REVISED 9-26-91

UTILITIES PLAN						
PERSONAL WAY AVIATION						
TOWN OF ADDISON, TEXAS						
DRAWN	DESIGN	DATE	SCALE	NOTES	FILE	NUMBER
N.W.L.	N.W.L.	9-18-91	1"=40'

UTILITIES PLAN						
PERSONAL WAY AVIATION						
TOWN OF ADDISON, TEXAS						
DRAWN	DESIGN	DATE	SCALE	NOTES	FILE	NUMBER
N.W.L.	N.W.L.	9-18-91	1"=40'

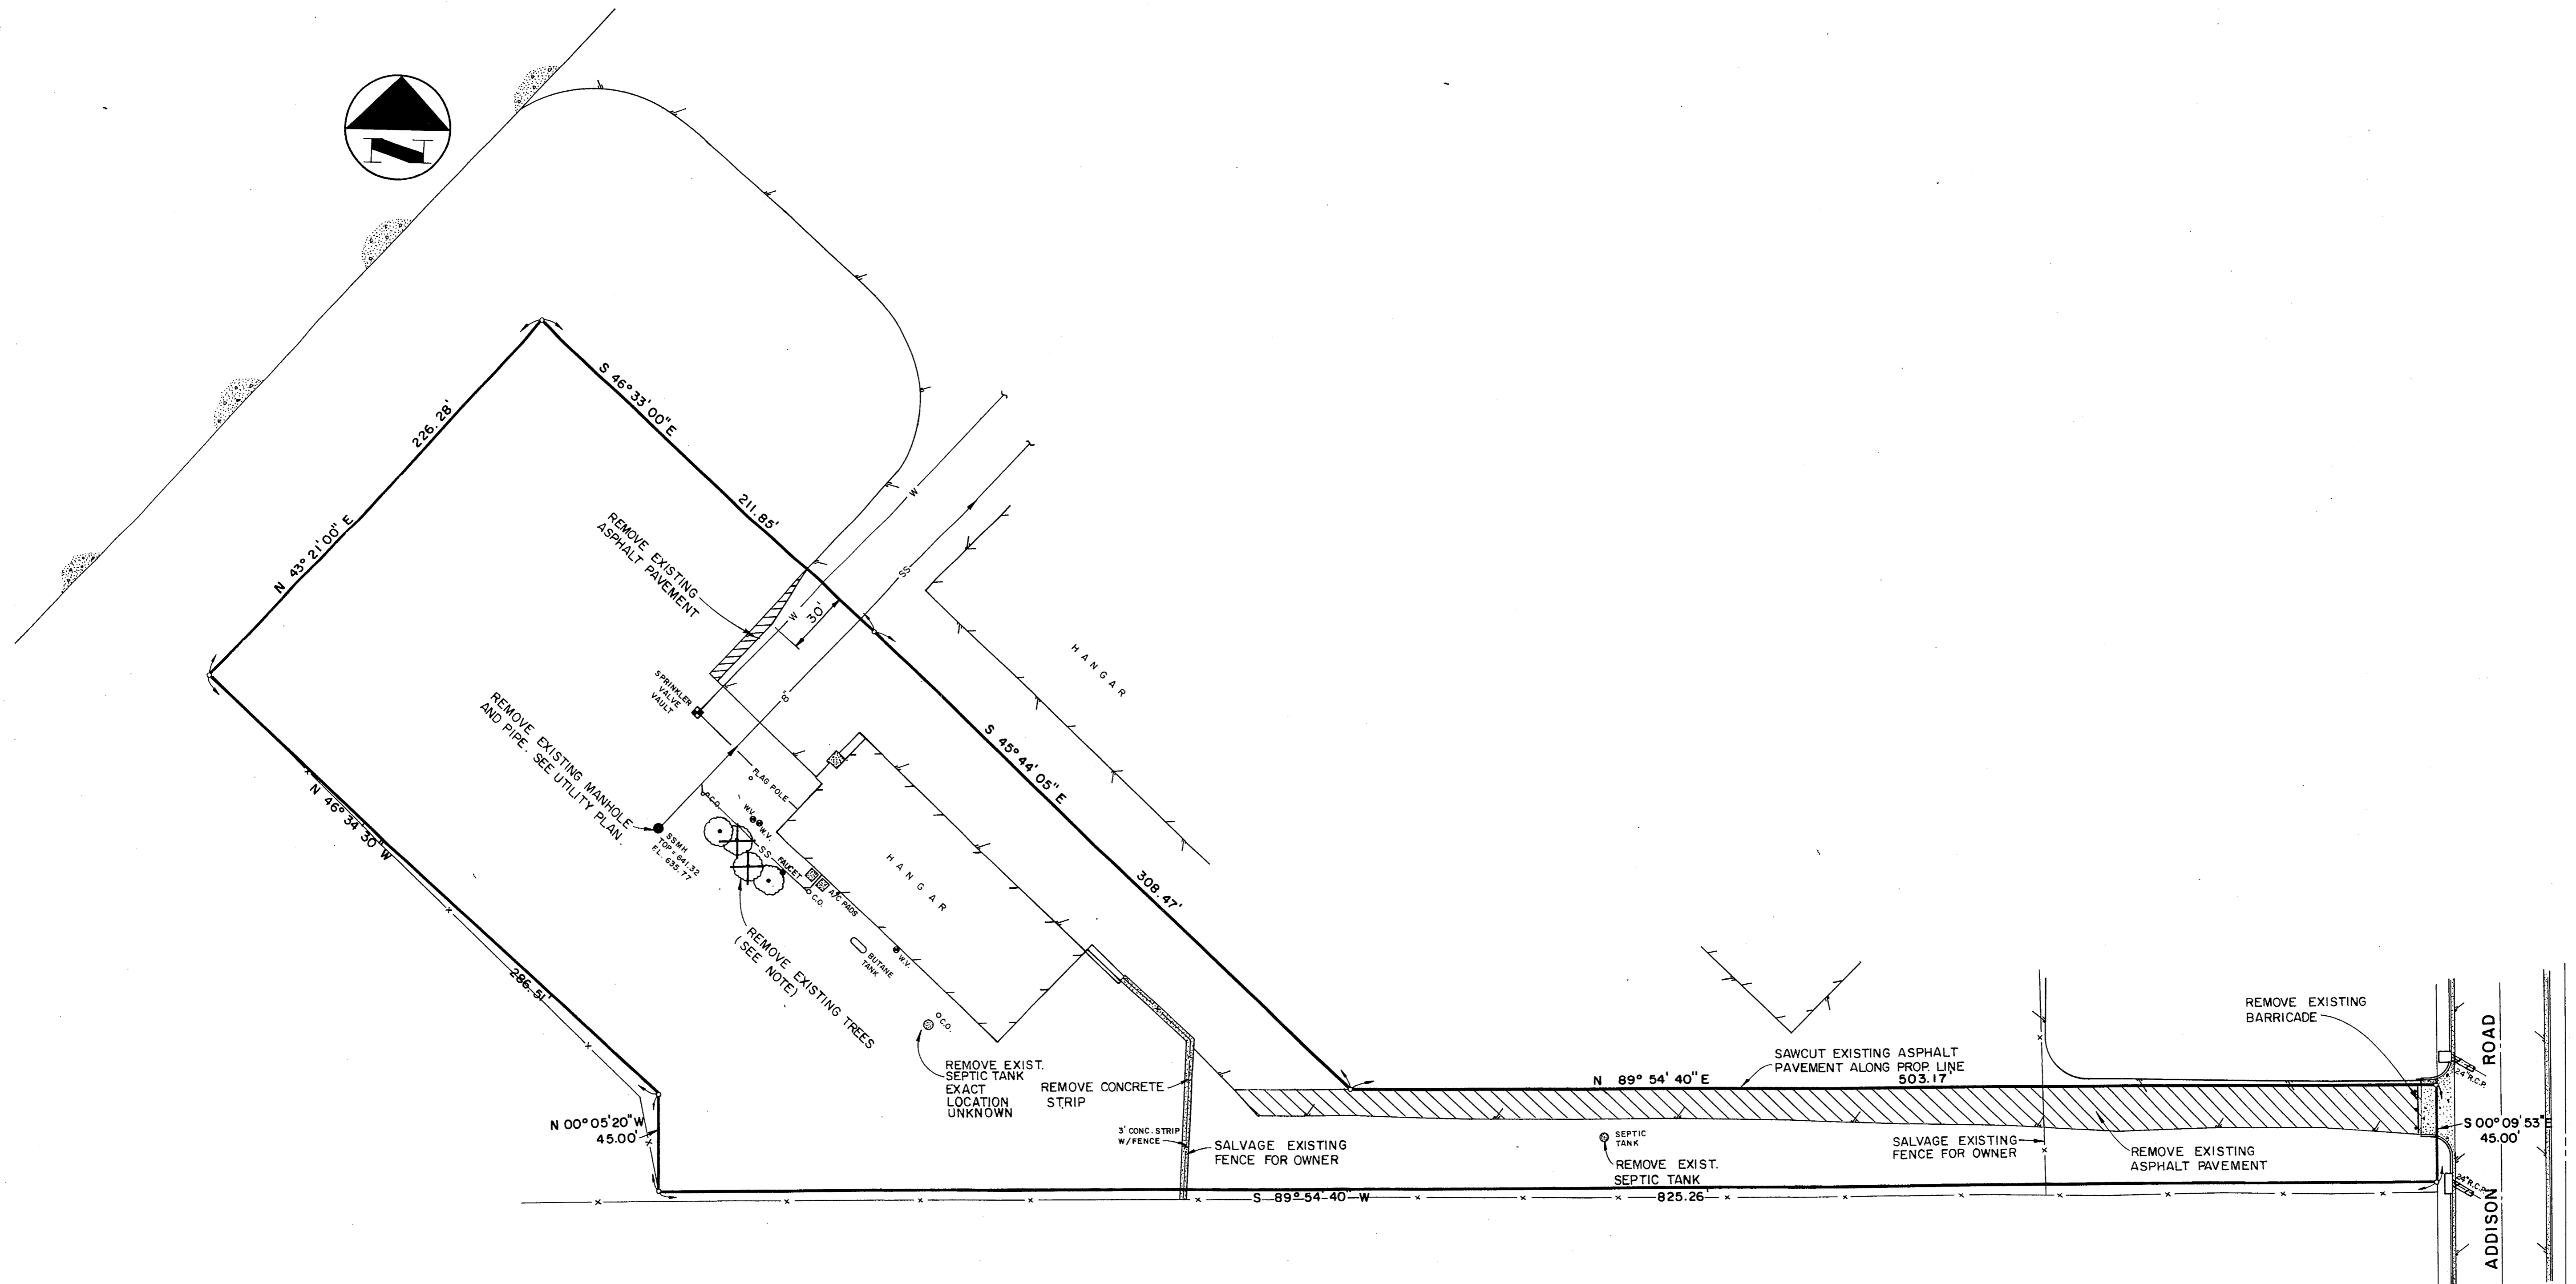
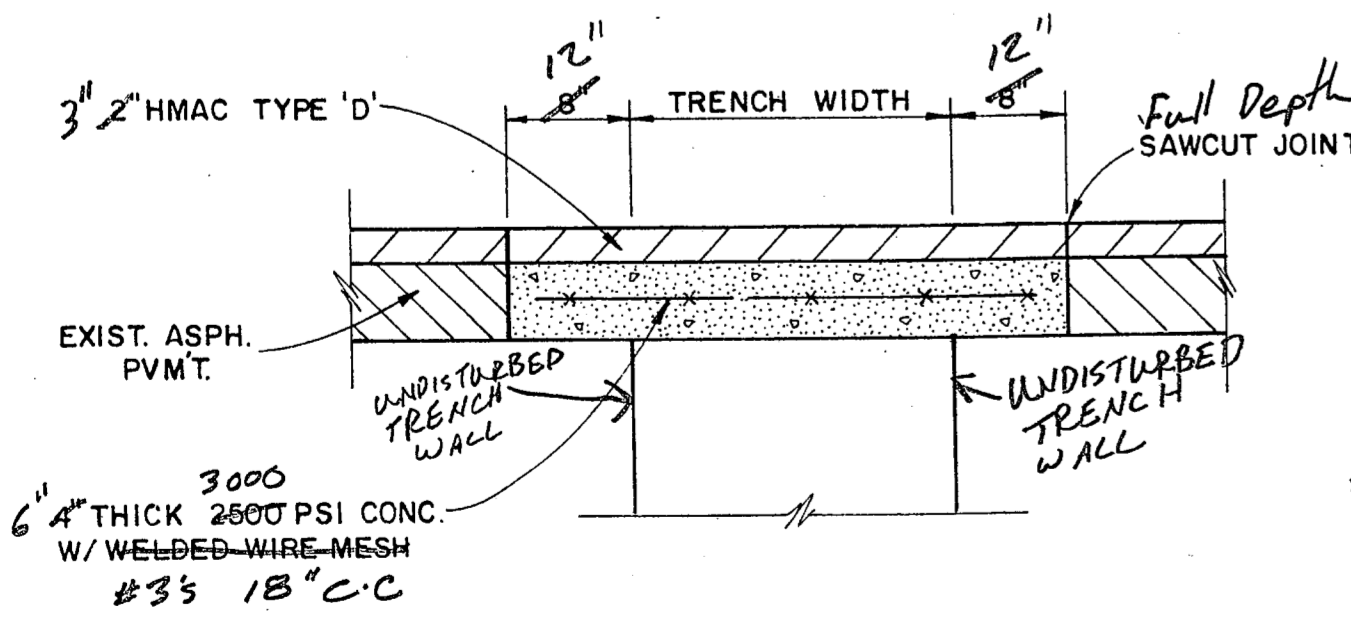
INSTALL:
2-2" TAPS W/DOMESTIC METERS (1 1/2")
1-1/4" TAP W/IRRIGATION METER (1")
*To be installed to city standards
Double Checked Required on ALL meter services
BE*

Sewer and Gas shall be installed so the sewer can be extended at a later date

1. As-Built Plan and profile shall be provided prior to sanitary sewer prior to C.O. As-Built shall be sealed by professional engineer. Inspections of the sewer shall be provided by Bruce Ellis 450-2847
2. See typical trench detail attached.
3. Call Bruce Ellis for sanitary sewer manhole details
